City of Portland, Maine - Building or Use Permit Application

Permit No: 08-0745	Issue Date:	CBL: 087 Y021001
------------------------------	--------------------	----------------------------

Location of Construction: 181 ISLAND AVE, Peaks Island	Owner Name: BURKHOLDER BRAD A	Owner Address: 181 ISLAND AVE	Phone: 207-766-2628
Business Name:	Contractor Name:	Contractor Address:	Phone:
Lessee/Buyer's Name	Phone:	Permit Type: Additions - Dwellings	Zone:

Past Use: Two Family Residential	Proposed Use: Two Family Residential - Rebuild 15 x 30 attached outbuilding	Permit Fee:	Cost of Work: \$60,000.00	CEO District: 1
Proposed Project Description: Rebuild 15 x 30 attached outbuilding		FIRE DEPT: <input type="checkbox"/> Approved <input type="checkbox"/> Denied	INSPECTION: Use Group: Type:	
		Signature:	Signature:	
PEDESTRIAN ACTIVITIES DISTRICT (P.A.D.)				
Action: <input type="checkbox"/> Approved <input type="checkbox"/> Approved w/Conditions <input type="checkbox"/> Denied				
Signature: Date:

CROSS SECTION OF EXISTING STRUCTURE

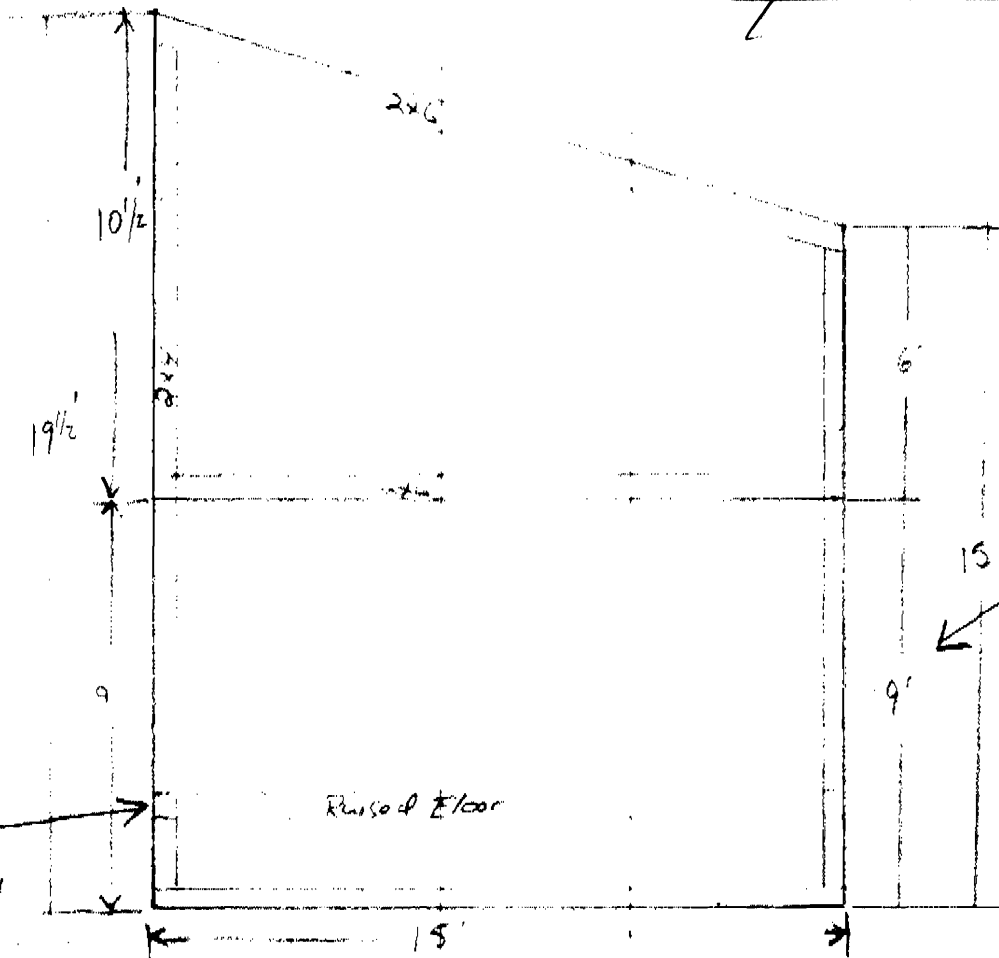
Note: Existing building is nonconforming to rear and side setbacks and it is over lot coverage. The attached 15' x 30' "outbuilding" is being rebuilt within the existing footprint but the roof is changing. There is no floor area being added to the second floor since the lowest existing wall was 6'. The volume is remaining about the same. **Ok to Issue:**

7/9/2008-amachado: Received pictures & plot plan 7/8/08. Shell of building is changing. Using section 14-436(b), need to have cross section of existing building to see how much floor area is being added. Spoke to Brad & he will get it to me.

8/20/2008-amachado: Received cross section of exiting building.

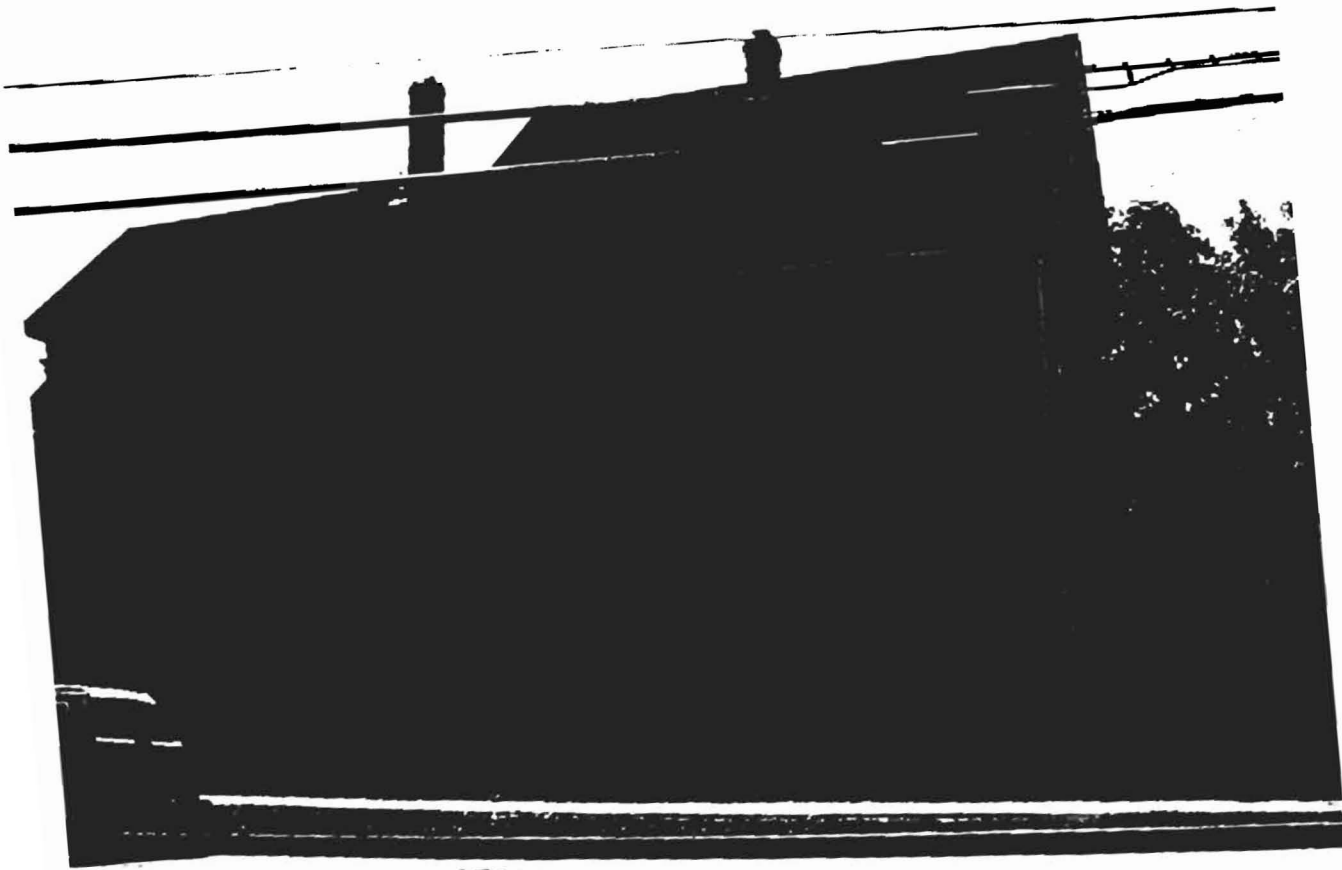
7/7/2008-amachado: Left message for Brad. Need plot plan. Need pictures of existing building from all three sides. Need to know if it is being rebuilt within the existing shell.
